**Re: SSD-5339 - Proposed Minto Resource Recycling Facility
No. 7 MONTORE ROAD, MINTO**

I refer to the Department's correspondence regarding the proposal to operate a resource recovery facility which will have the capacity to process 450,000 tonnes per annum of concrete, brick, asphalt, sandstone and sand from the building and construction industry. The facility also proposes a range of crushing, screening, sand washing equipment used to process this material, including a pug mill.

DRAWING TITLE  
EARTHWORKS SECTIONS  
SHEET 02

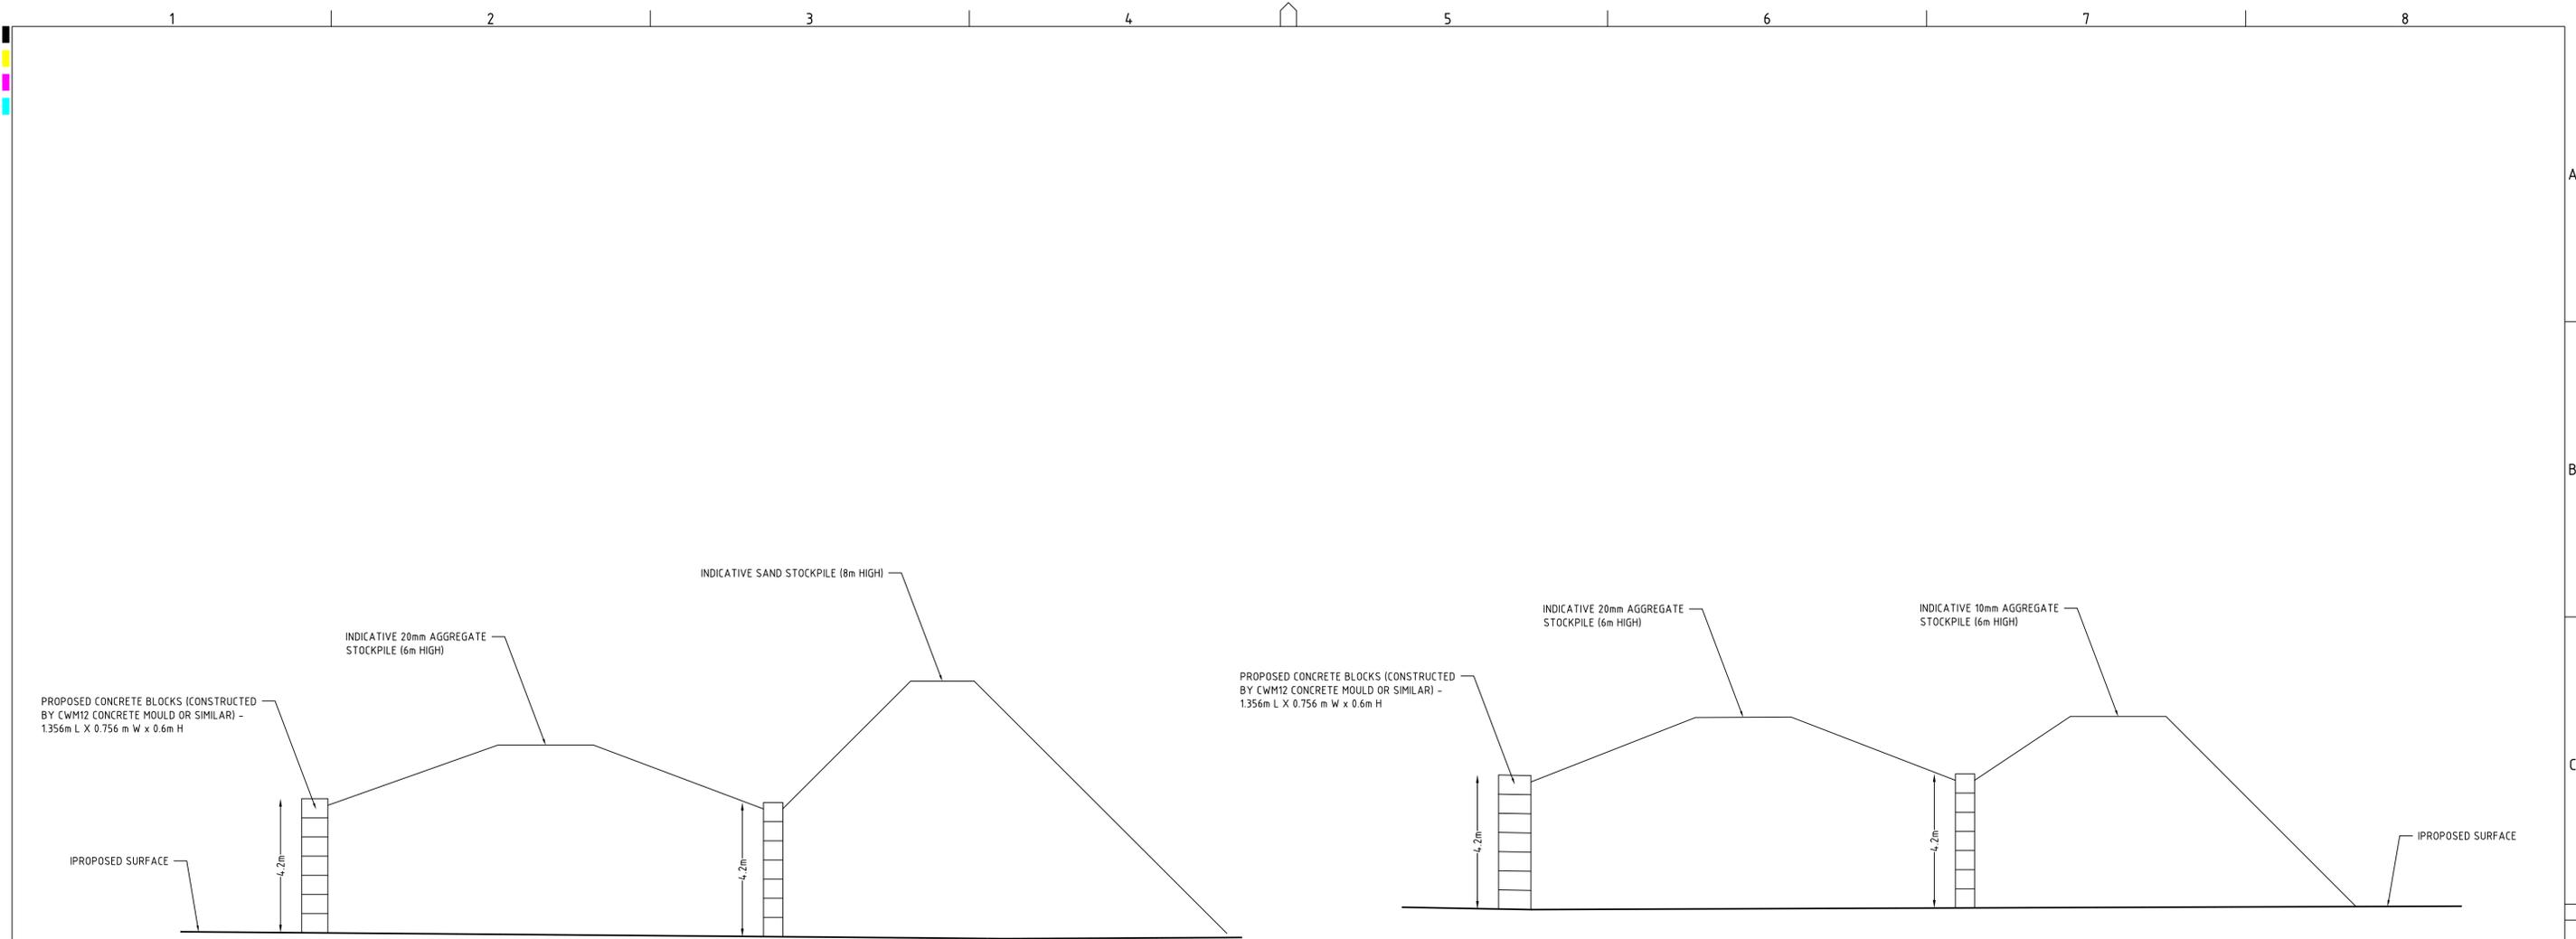
2. The Site Earthworks Plan, completed by Martens & Associates Consulting Engineers, dated 26/06/2020 does not include chainages on the plan sections. This makes interpreting the information presented in the cross and long sections difficult. The changes should be labelled to facilitate more detailed review.

DRAWING TITLE SITE LOADING & UNLOADING PLAN				
PROJECT NO. P1203464	PLANSET NO. PS02	RELEASE NO. R21	DRAWING NO. PS02-DZ10	REVISION F

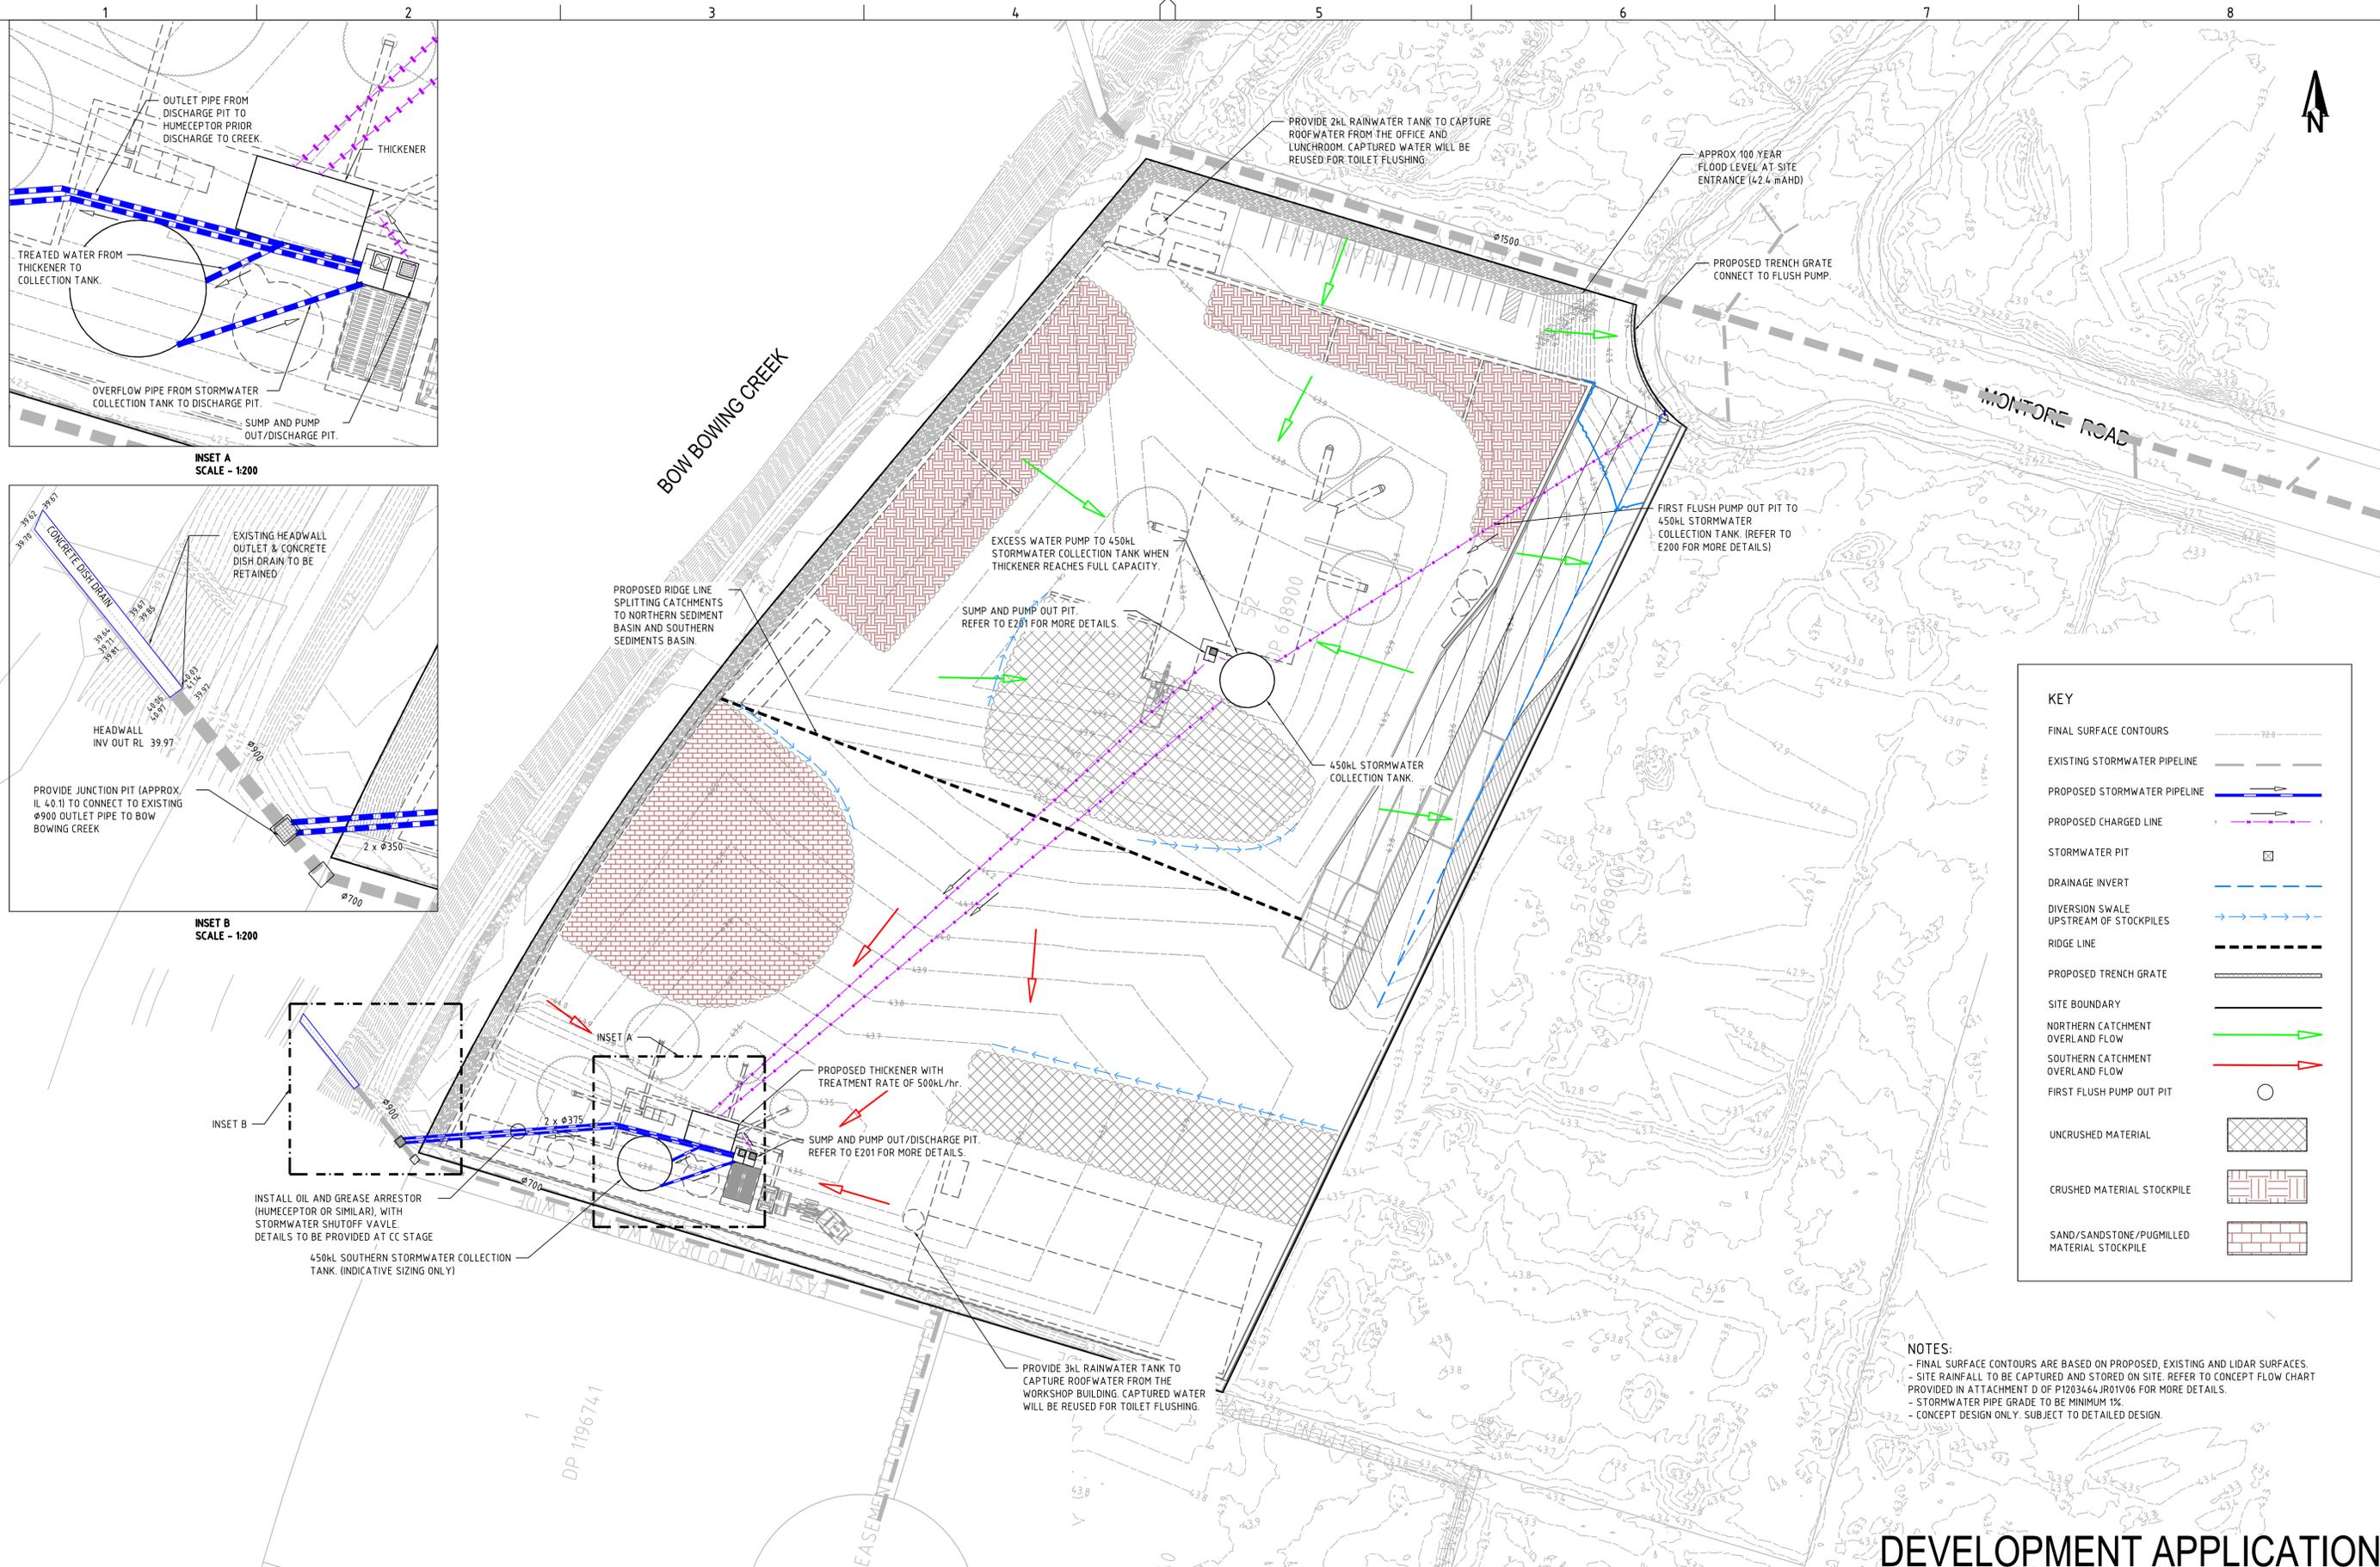
Further, the submitted ‘Traffic Impact Assessment’ at Appendix 8 fails to indicate whether the proposed vehicle loading/unloading areas will be open or uncovered. Any unloading in an open area is likely to result in the generation of high volumes of airborne particulate matter as vehicles during these operations. The simple practice of an employee applying a hose to suppress dust during these processes is considered to be ineffective and not likely to adequately mitigate this risk.

As a result, it is also recommended that a condition be imposed requiring all unloading and loading operations proposed on site be conducted from within inside an enclosed or covered area, fitted with an adequate misting system.

MUSIC CATCHMENT PLAN

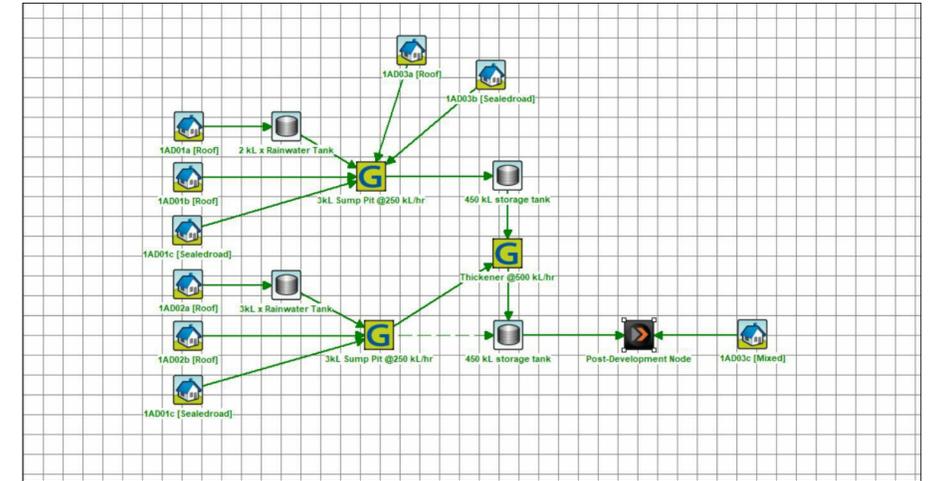
- a) Not all of the runoff is directed towards the sedimentation basins. Considering the use of the site, this is not acceptable and will lead to a high level of sediment being discharged

- b) The emergency overflow weirs have no treatment preventing sediment and other contaminants being washed from the site.
 - c) Considering the nature of the site, all flows to be treated prior to discharge.

- d) The following water quality targets must be met:
 - Total Suspended Solids – 85% Reduction
 - Total Nitrogen – 45% Reduction
 - Total Phosphorus – 45% Reduction

- e) Appropriate pollutant generation rates for the development must be used to ensure appropriate pollutants are present in the modelling and the treatment devices are working accordingly.

- f) Only sedimentation basins are proposed, these are not sufficient to treat TN and TP.
